Civil / Stormwater Responses to SSD 6962 BCC Conditions – 60 Wallgrove Road, Eastern Creek

Further to our meeting with you on the 28th of September, please find below a detailed summary of the points raised by Council in your letter dated 7th September 2015.

No.	Proposed Condition	AT&L / Mirvac Comments
2.7.1	Amended drainage plans from AT&L consultants (reference 12-108, revision B dated 28 May 2015) are to be provided to meet the requirements under Council's DCP Part R 2006 and Councils Engineering Guide for Development 2005. The amended plans must address the following:	Condition accepted – No changes proposed.

Suite 702, 154 Pacific Hwy St Leonards NSW 2065 ABN 96 130 882 405 Tel: 02 9439 1777 Fax: 02 9460 8413 www.atl.net.au info@atl.net.au		
Status	FOR APPROVAL NOT TO BE USED FOR CONSTRUCTION	A1
Drawing No.	DAC031	Issue
Project No.	12-108	B

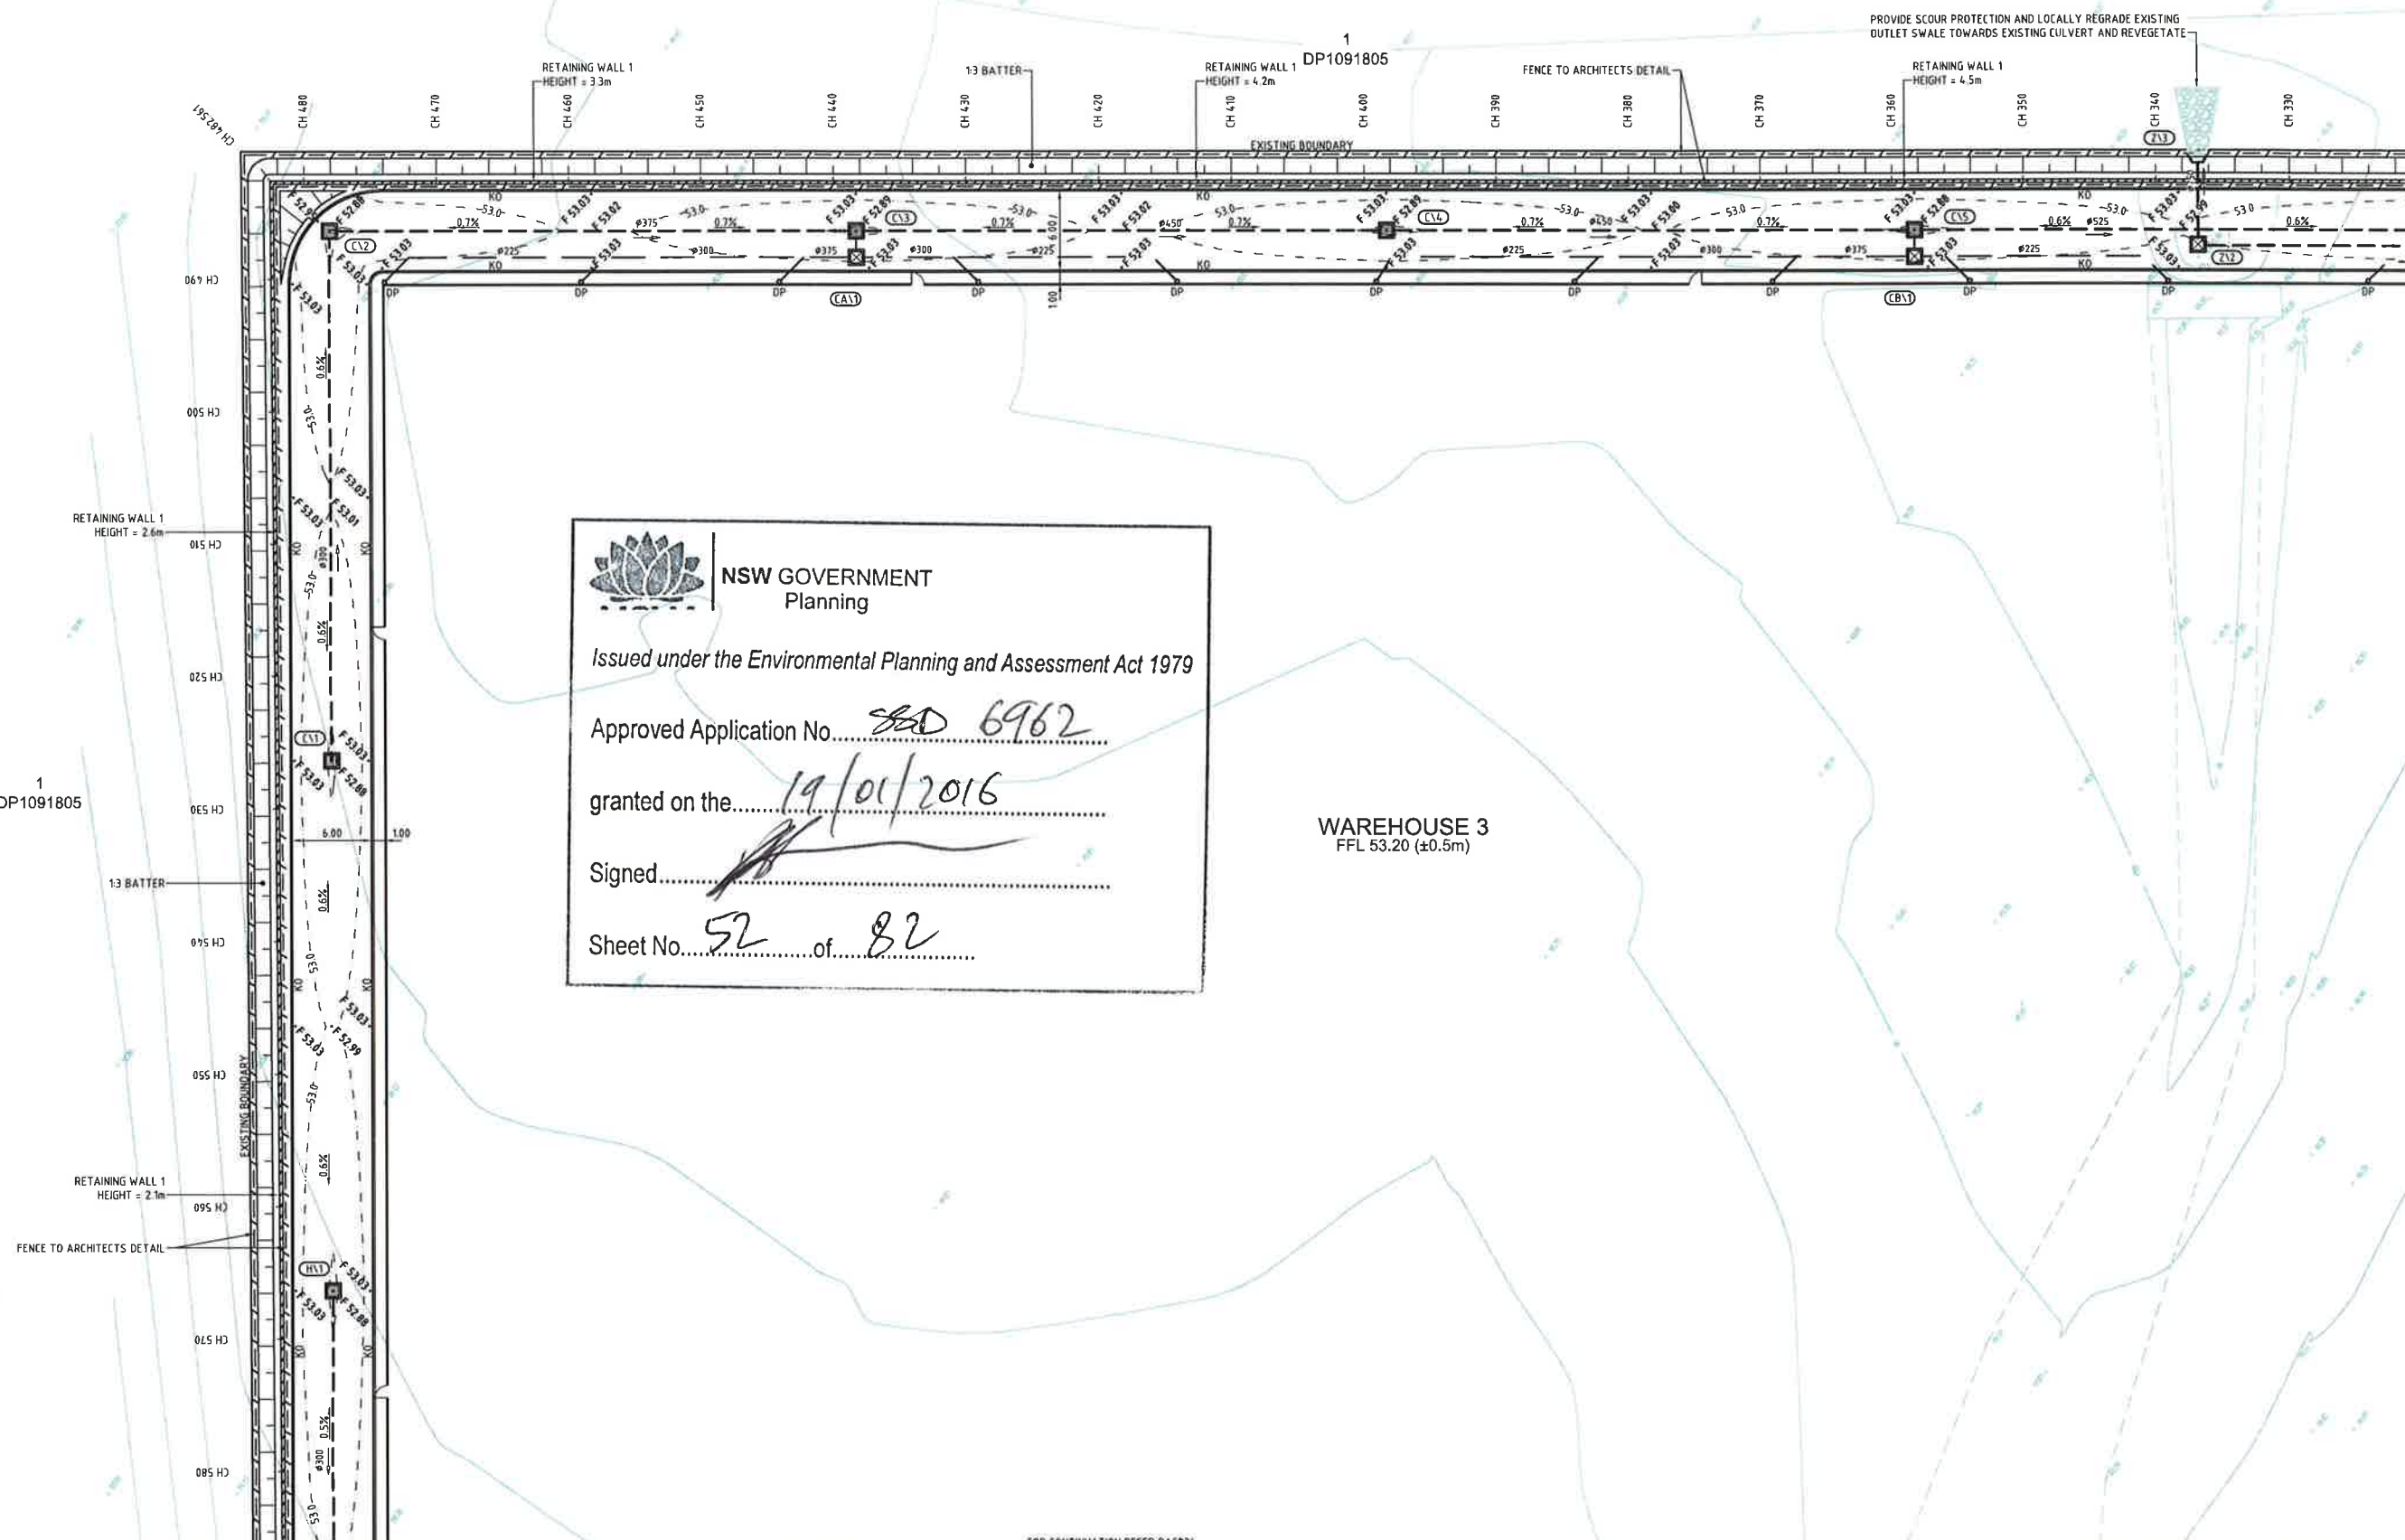
2.7.1 (v)	On plan DAC031 <ul style="list-style-type: none"> - Reconfigure the drainage for 50% of roof water to discharge direct to the rainwater tanks and not to the surface drainage system. - Obtain written approval from the downstream property owner agreeing to allow access to their site and allowing the installation of the scour protection within their property. 	<p>To be deleted. Refer to new clause 7.1.12. <u>2-7-12</u>?</p> <p>Condition accepted – No changes proposed</p>	<p>OK</p> <p>OK</p>

Drawing No.	DAC032	Issue																																						
Project No.	12-108	B

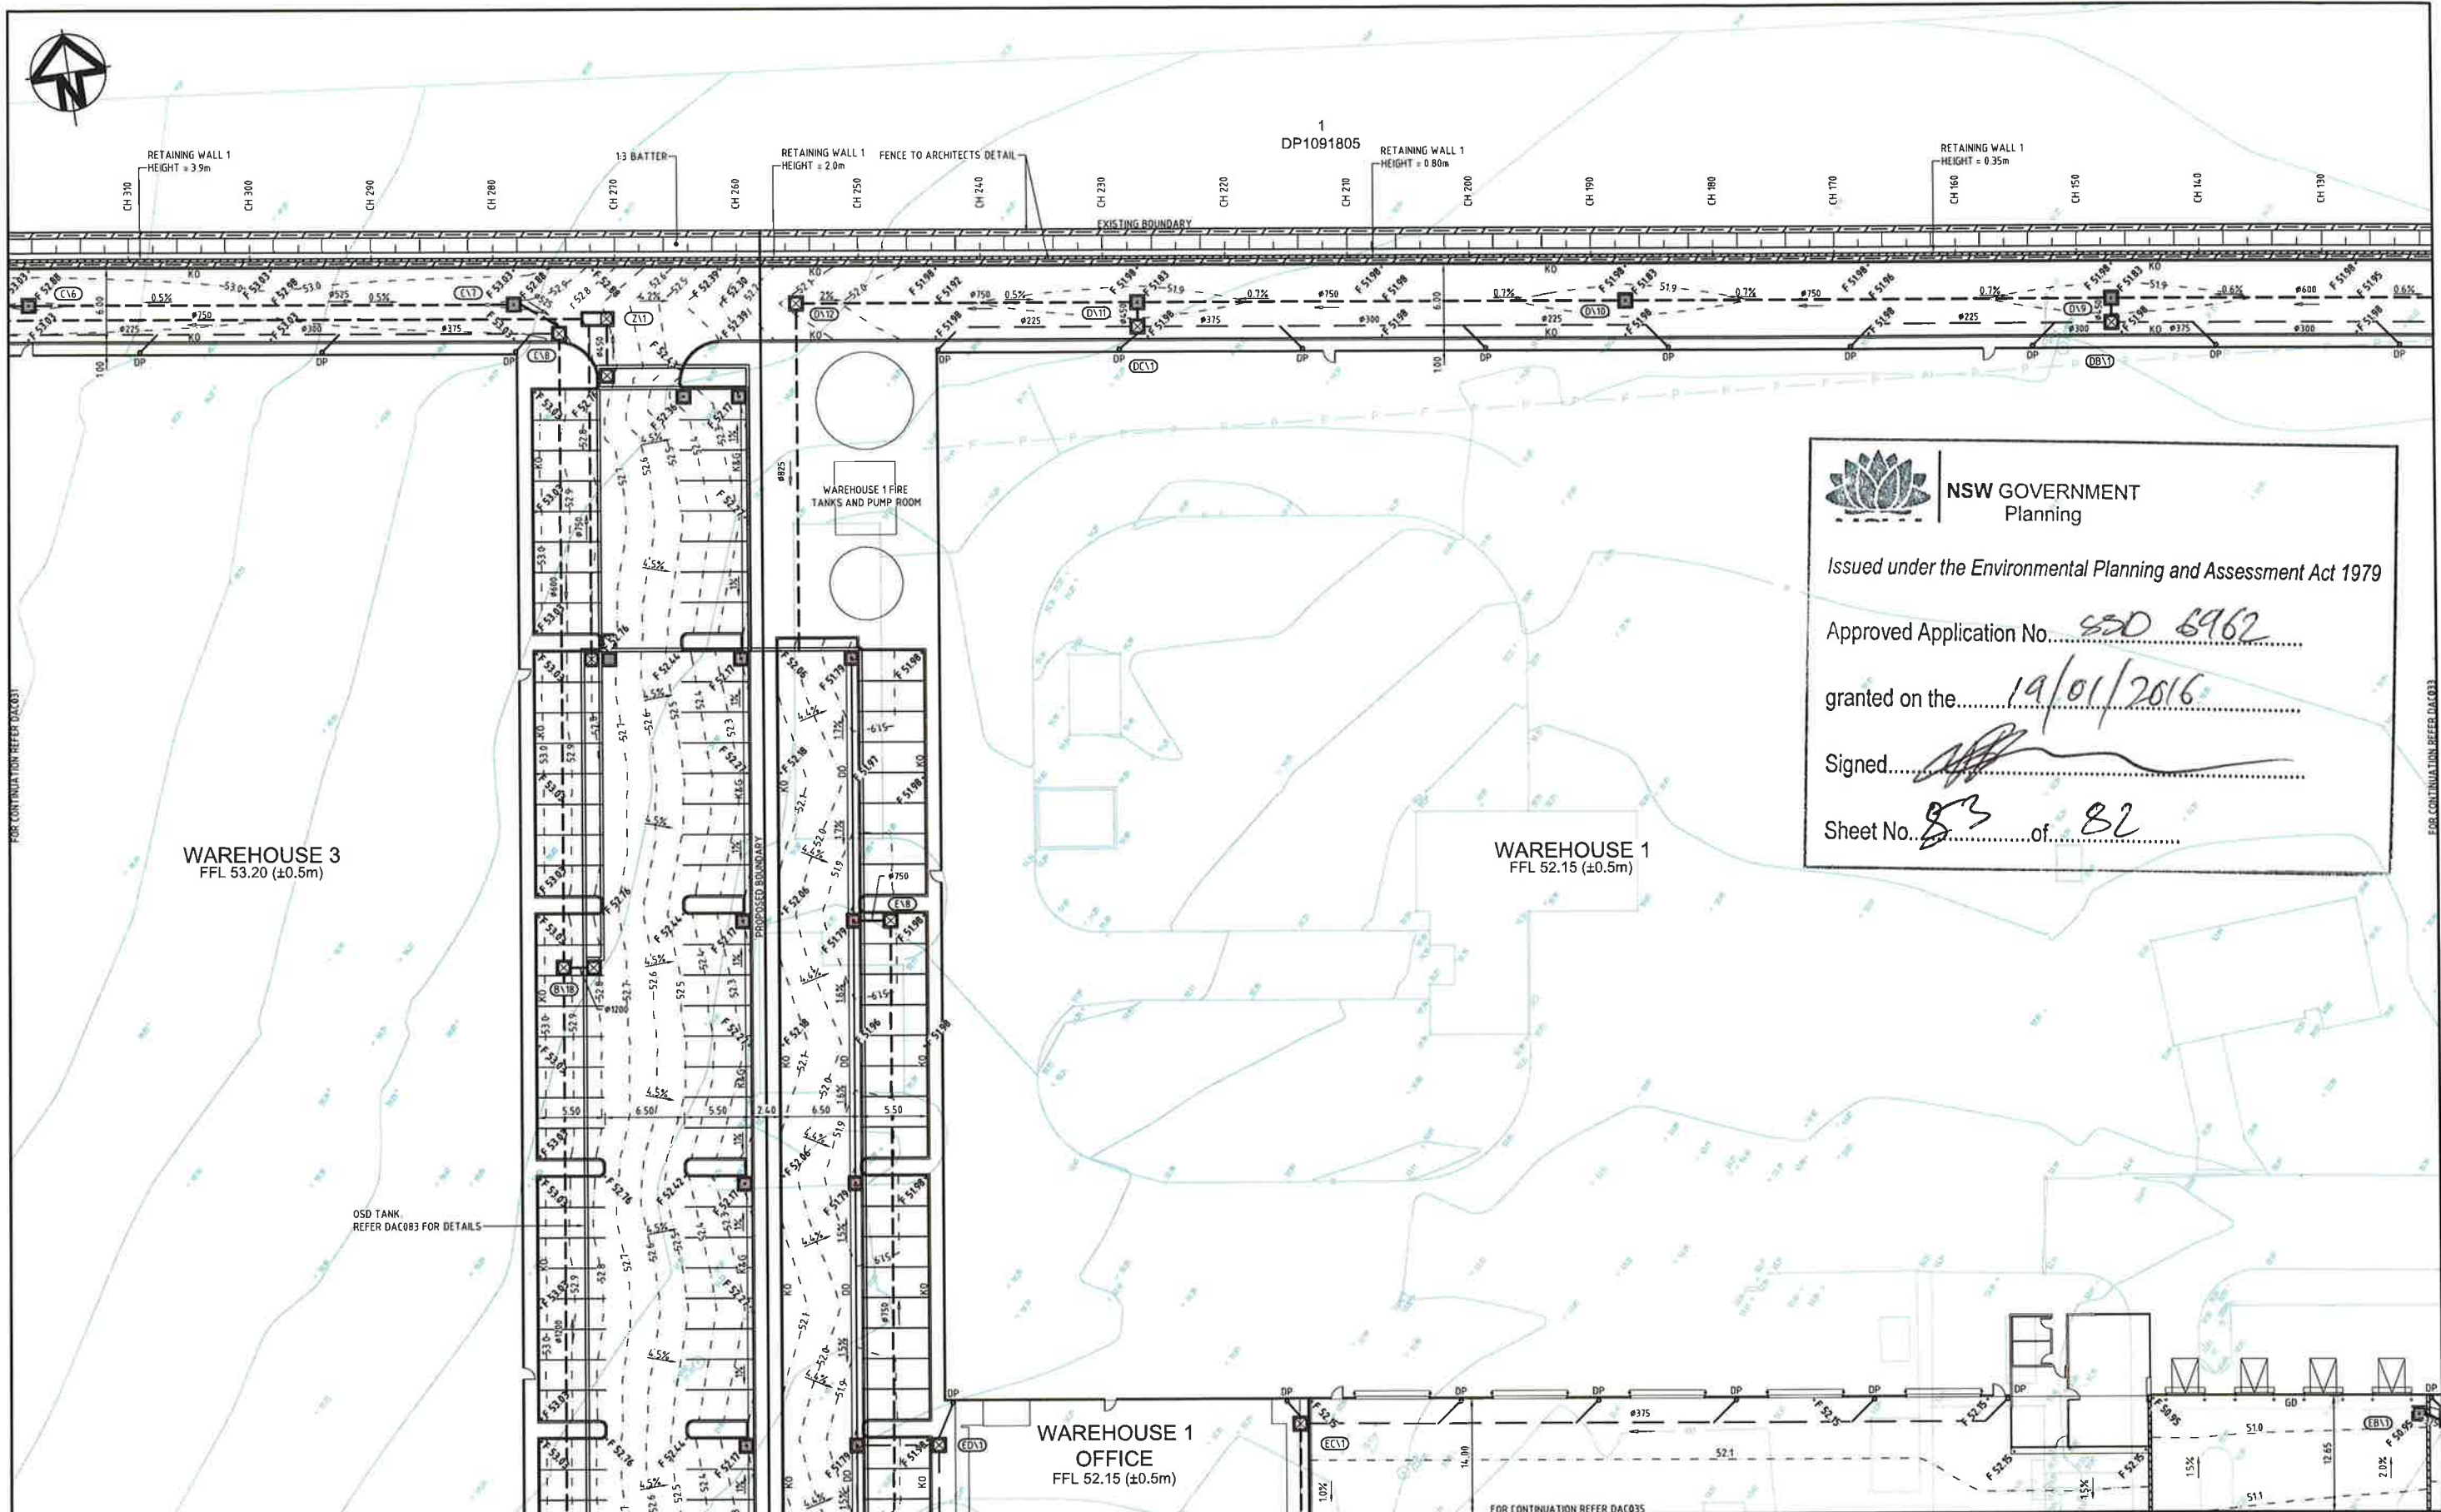
2.7.1 (vi)	On plan DAC032 <ul style="list-style-type: none"> - Reconfigure the drainage for 50% of roof water to discharge direct to the rainwater tanks and not to the surface drainage system. - Council recommends there are insufficient access gates for the below ground detention tank and Stormfilter chamber. Council recommends that access gates to the below ground detention tank should be a minimum 900 mm by 900 mm and are positioned such that the maximum distance from any point in the tank to the nearest grate is not greater than 6 m. Council understands that ownership and maintenance responsibilities for the below ground detention tank will remain with the Developer, and that the Developer may alter the configuration of access gates subject to completion of a satisfactory risk assessment, and compliance with the relevant WHS and Confined Space Access requirements. 	<p>To be deleted. Refer to new clause 7.1.12. <u>2-7-12</u>?</p> <p>Disagree Clause amended as discussed.</p> <p>Keep as is.</p>	<p>OK</p> <p>NO</p>
